Consultation response from KC PROW (footpaths)

2025/91053 – Land off Wood Lane, Colnebridge

Change of use and alterations to barn to form 3 dwellings including associated works

Date Responded : 8/5/25

**Post-Development Plan
Post-Development Map**

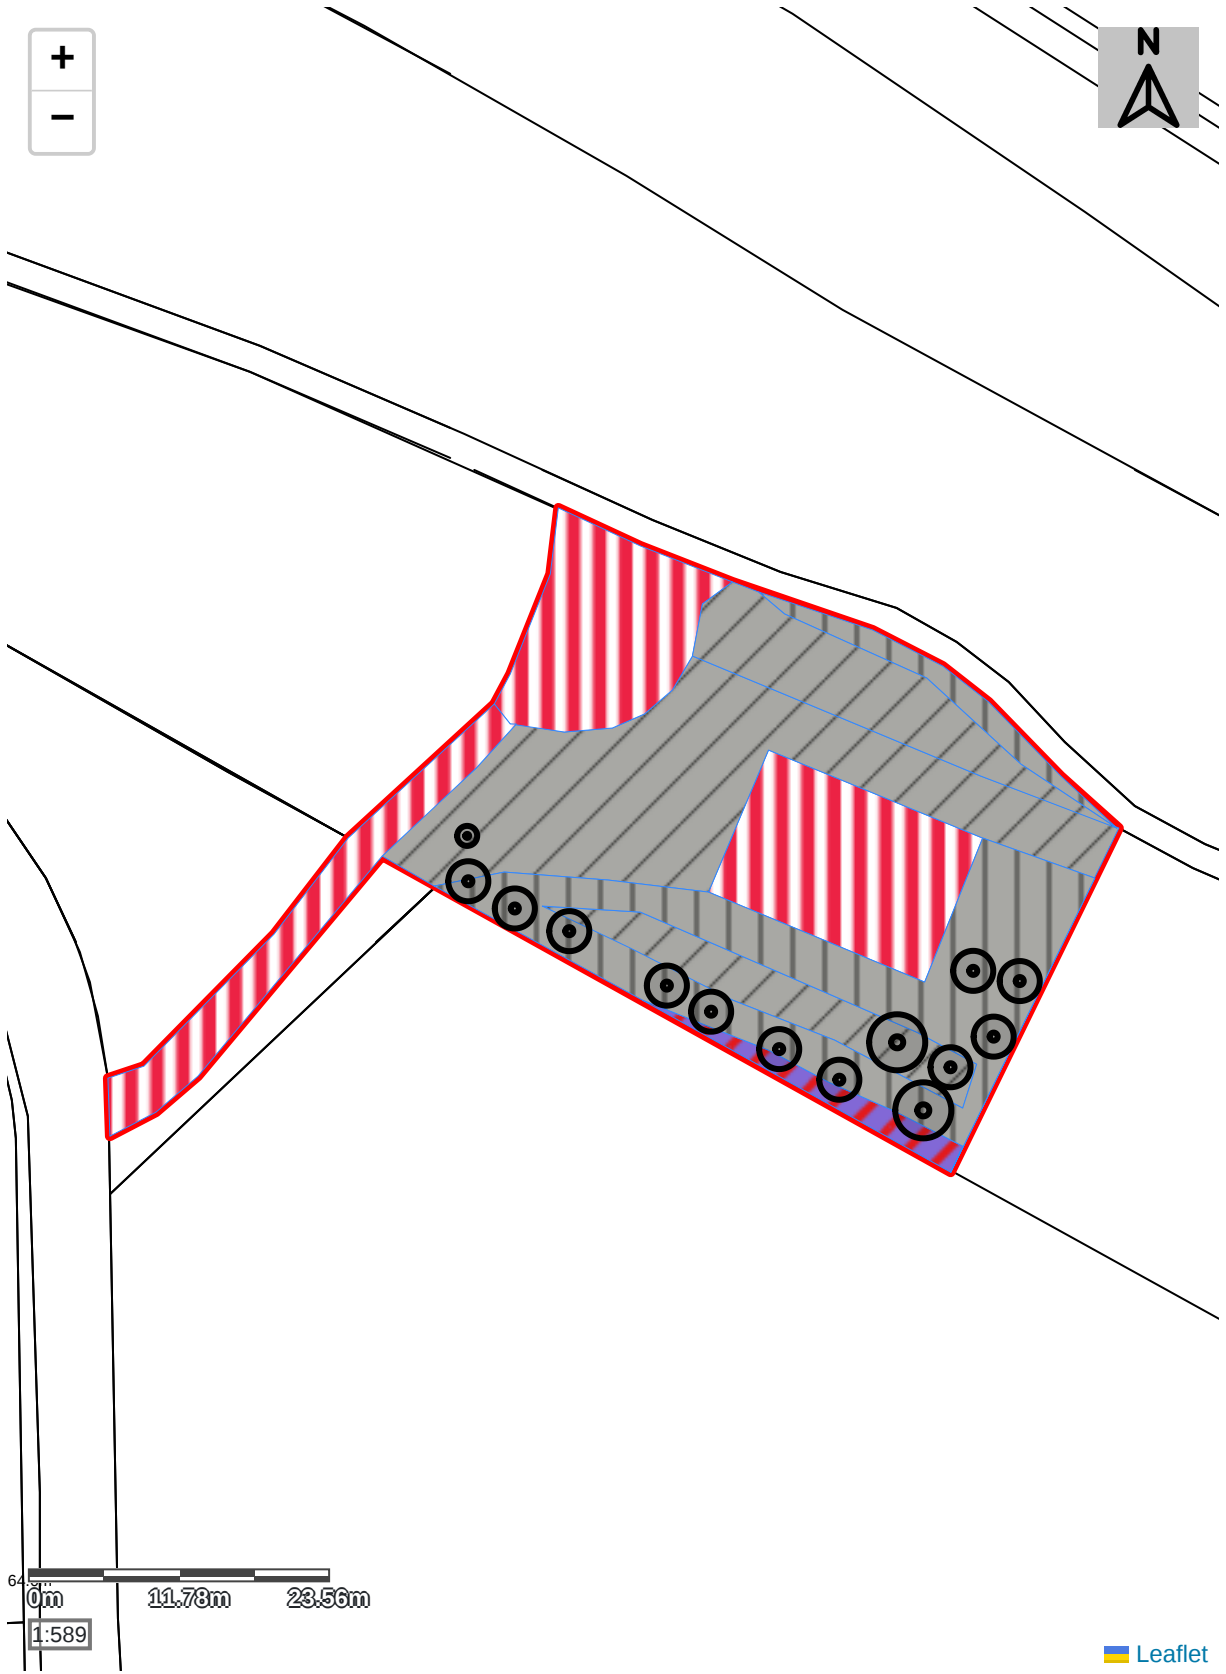
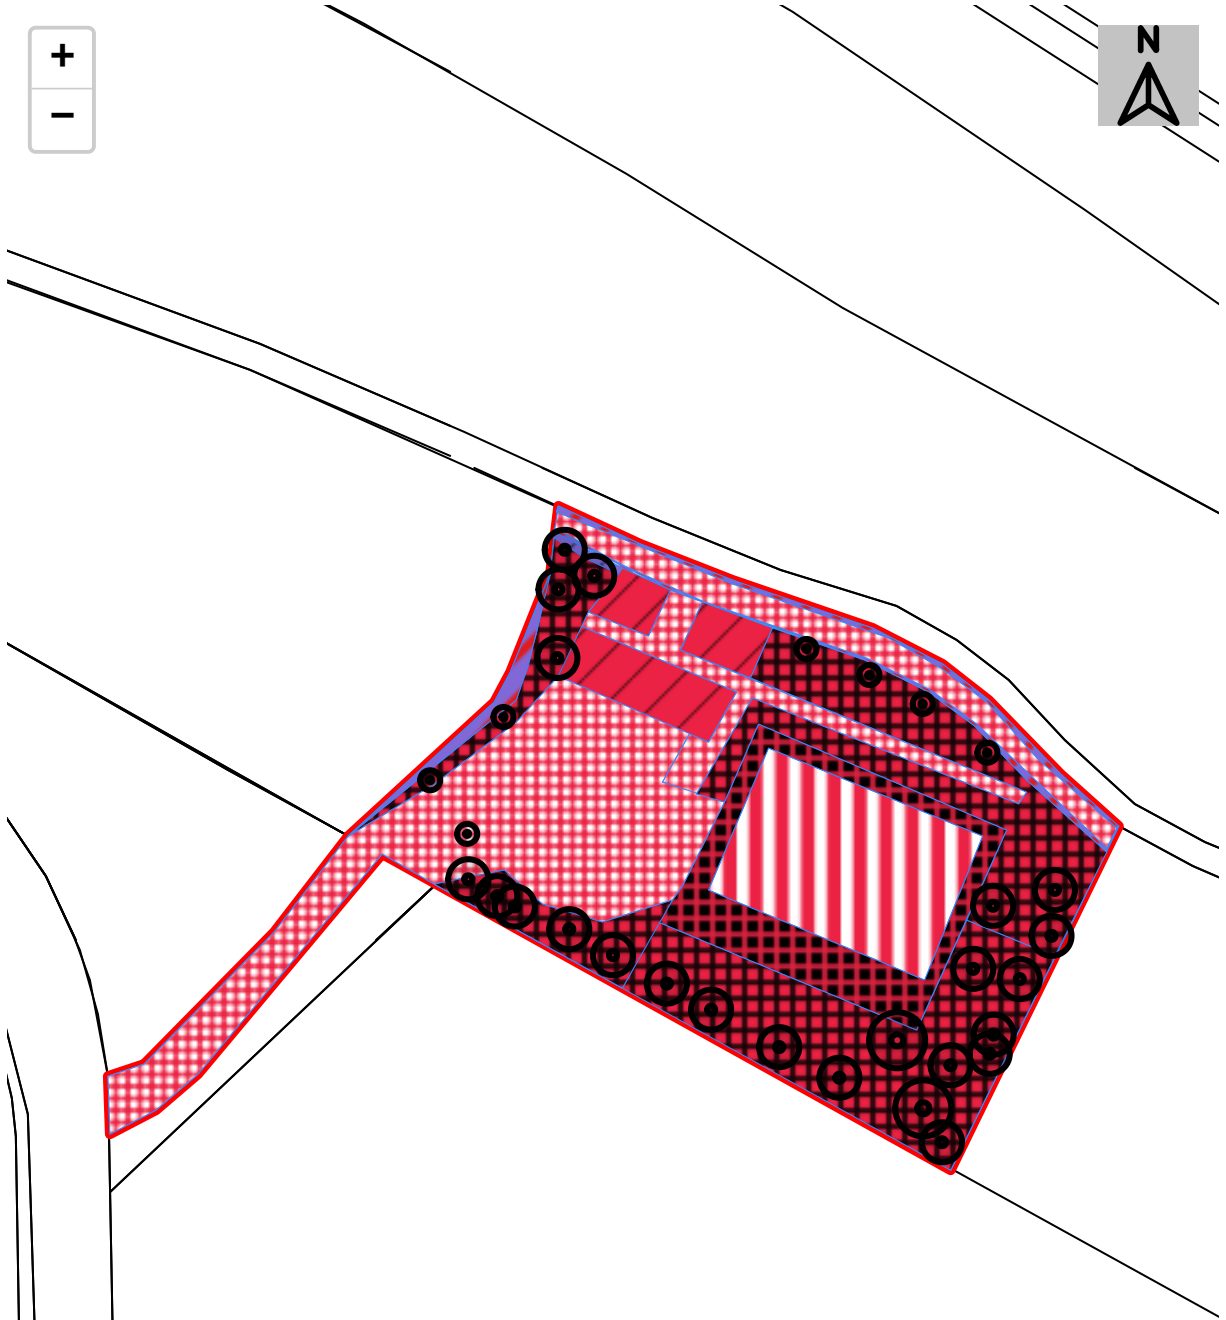
Public bridleway Kirkburton 251 runs through the site and Prow would object to the application on the information submitted.

The recorded alignment of the bridleway is not where the cycle path is on the ground and not where the submissions show the route. The development proposes to build on the bridleway and the route is currently obstructed by fencing.

Prow would welcome a conversation with the landowner regarding the reopening of the definitive alignment.
